Planning & Urban Development Department

July 2, 2014

RE: 80-84 Best Street – 134-D-9 & 10 – The Richardson Farm Condominium Association (the
"Property") – R-5 Zone

**Amended Condominium Plat
Richardson Farm Condominium**

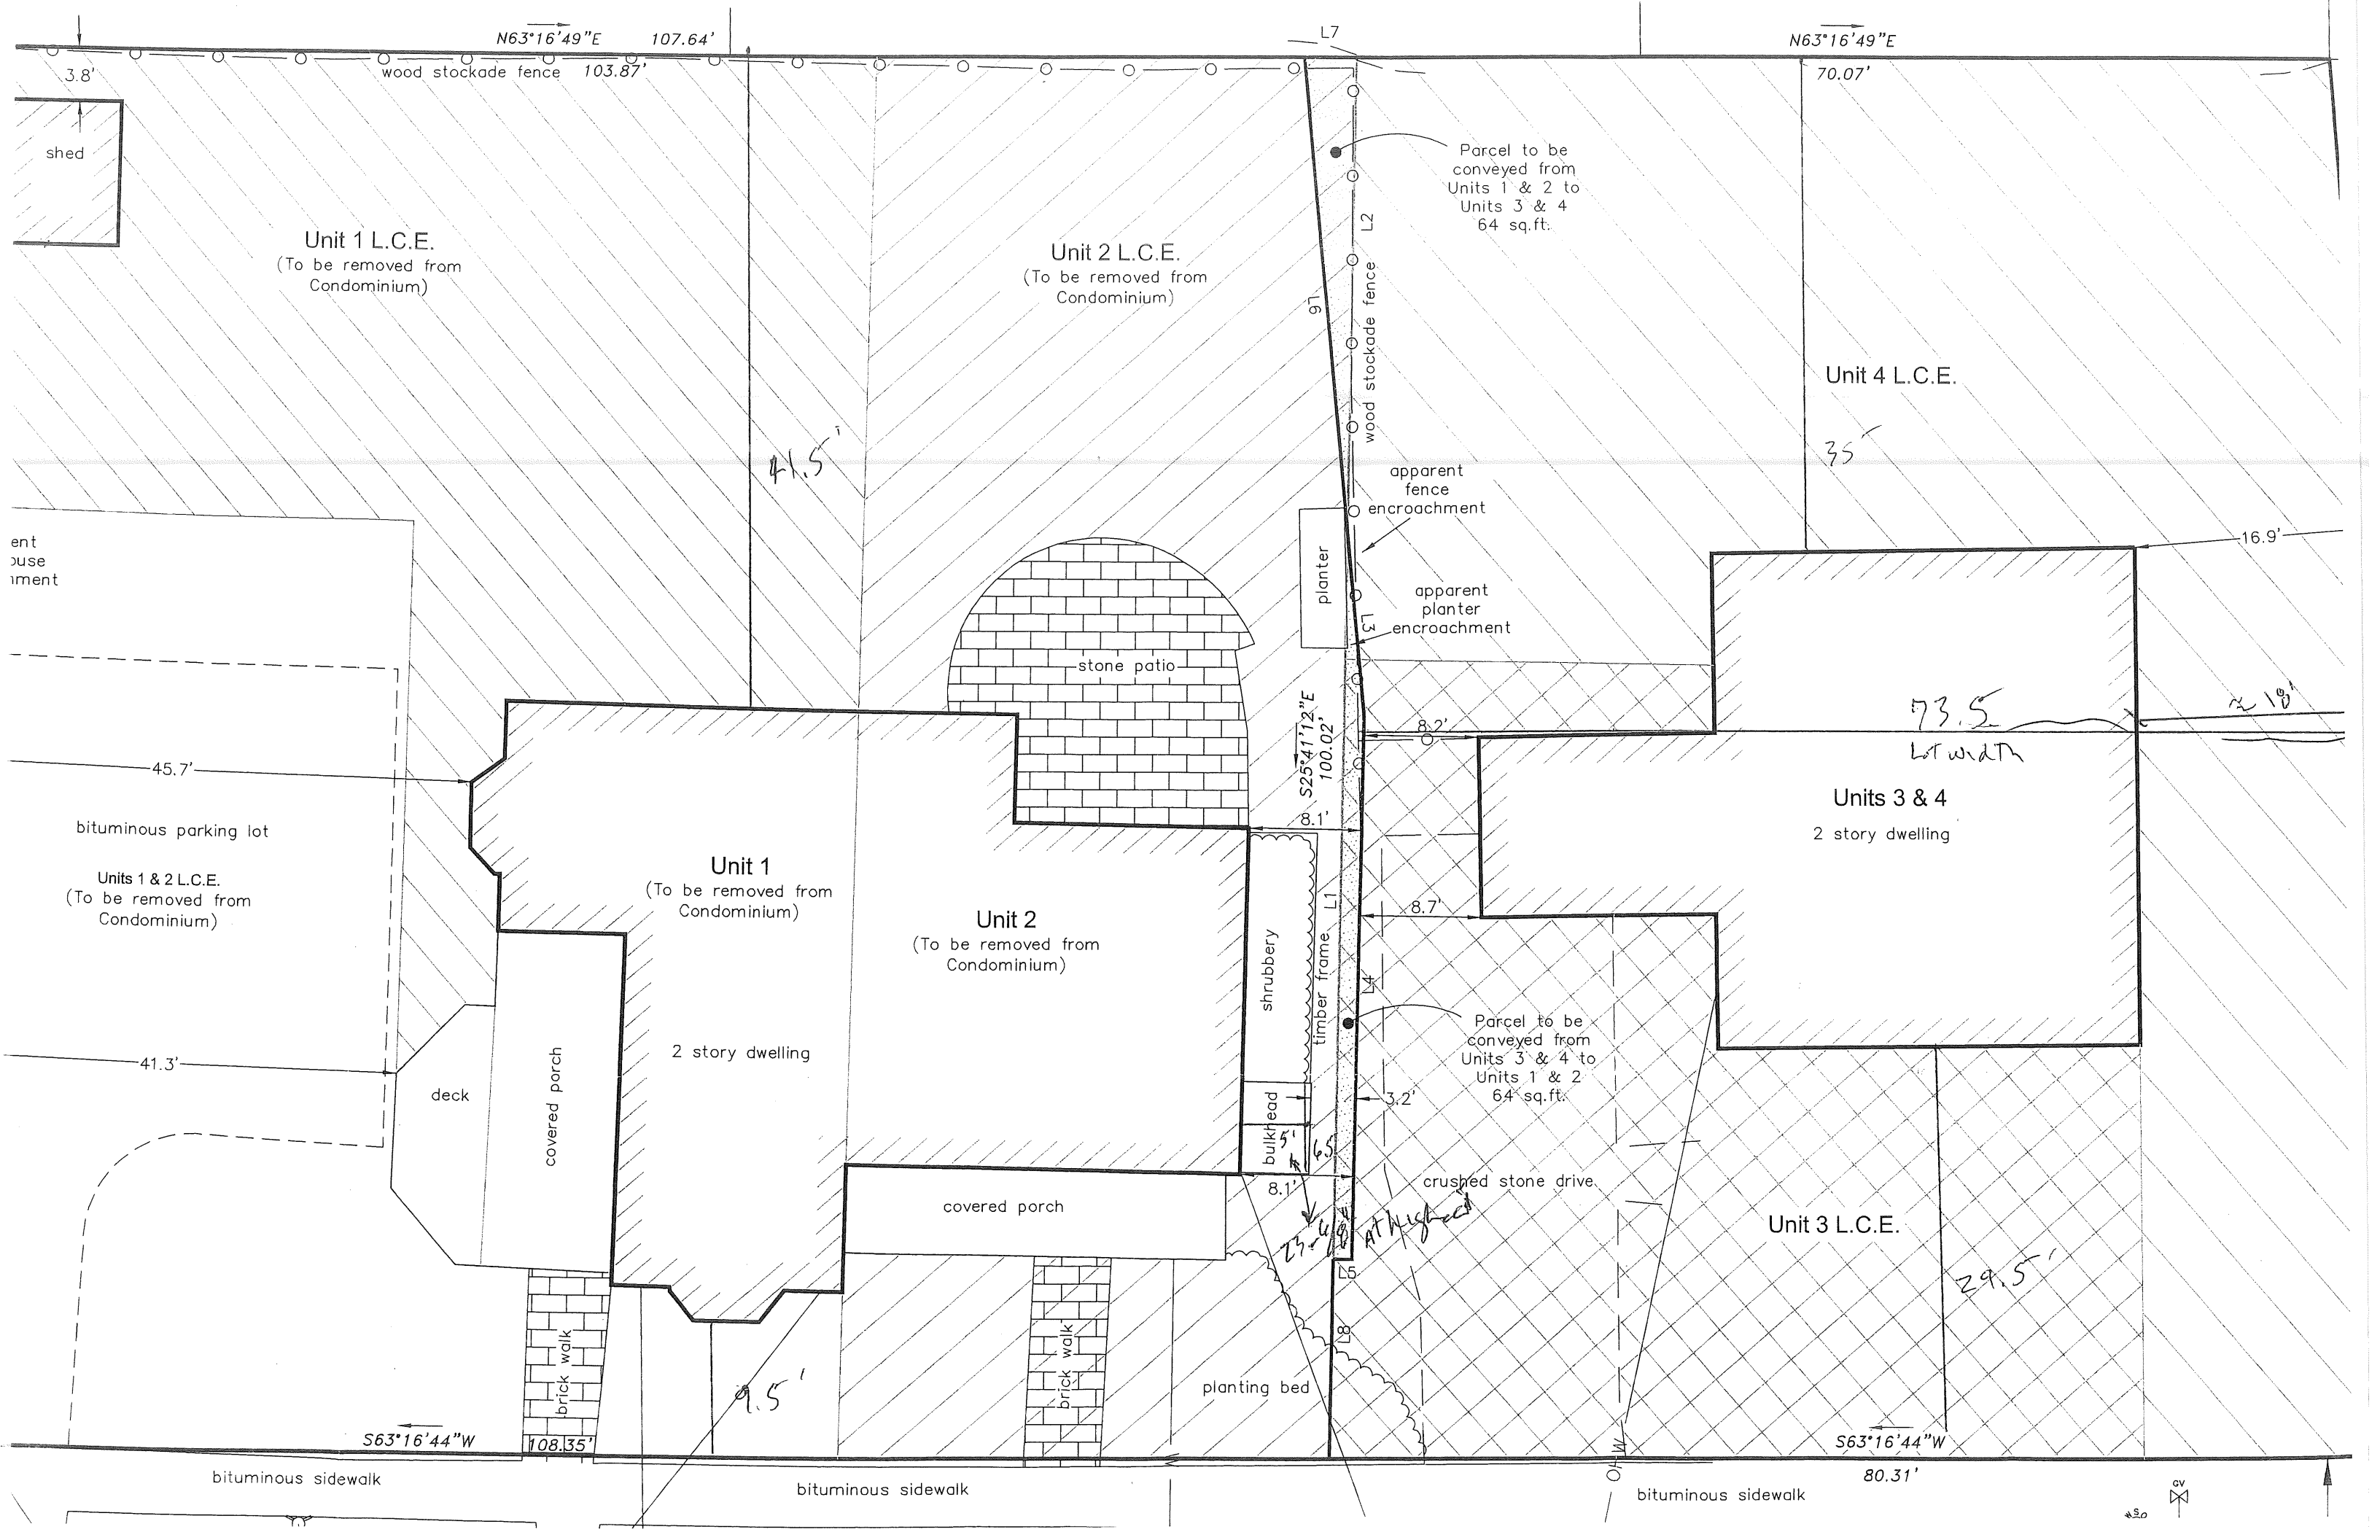
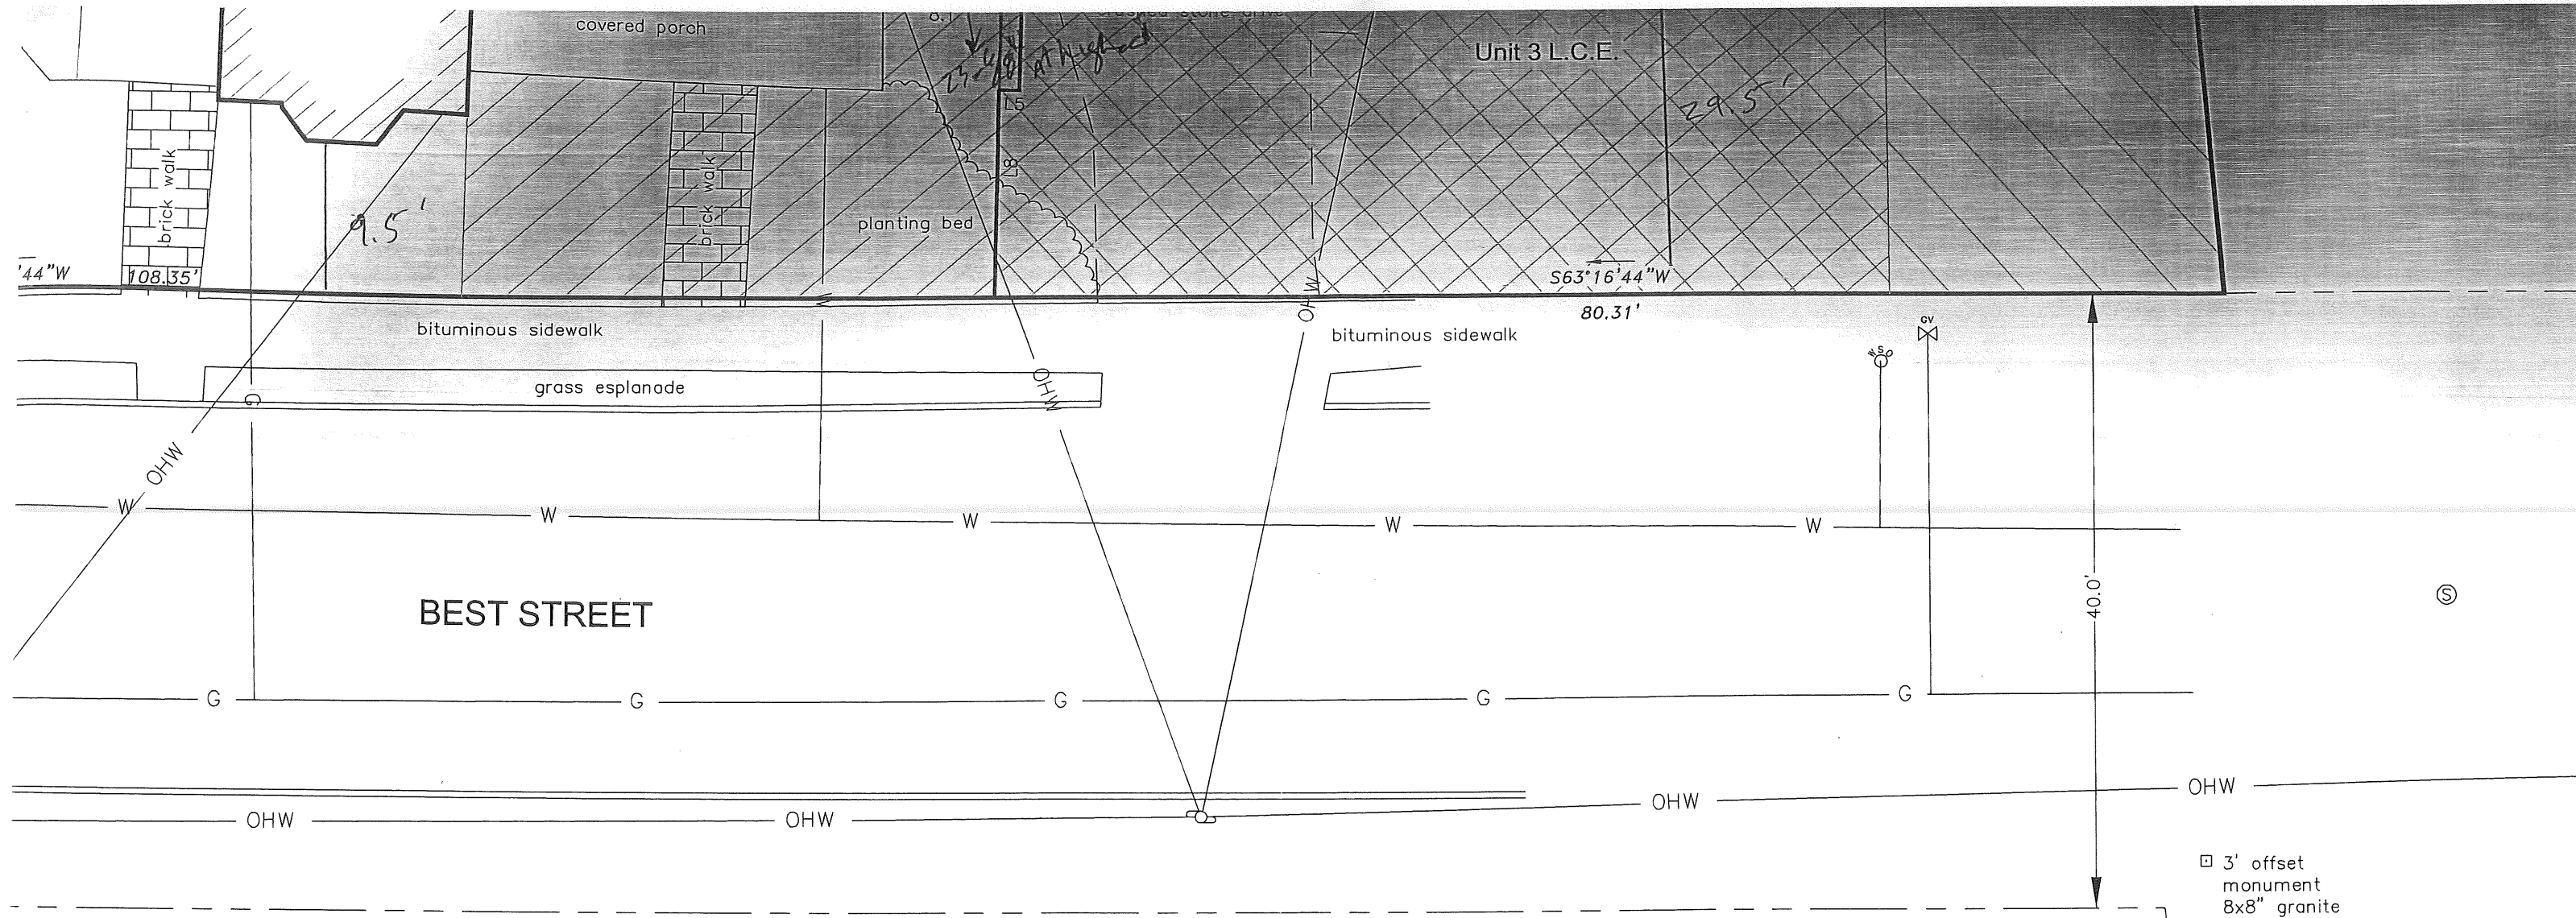
14-426 allows basement bulkheads to be sited within a setback, the side setback in this case, if the bulkhead is less than fifty (50) square feet in size and does not project from the building more than six(6) feet and is no more than twenty-four (24) inches in height. You have confirmed that the highest point of the bulkhead is approximately 23- 6/8 inches. Therefore, the shown bulkhead on the side of the Unit 1 and Unit 2 building is meeting the current Land Use Zoning Ordinance.

I have determined that the proposed division of land as shown on the submitted survey would not violate the current R-5 zone, including the dimensional requirements. Both lots are in compliance with the R-5 zone requirements as shown.
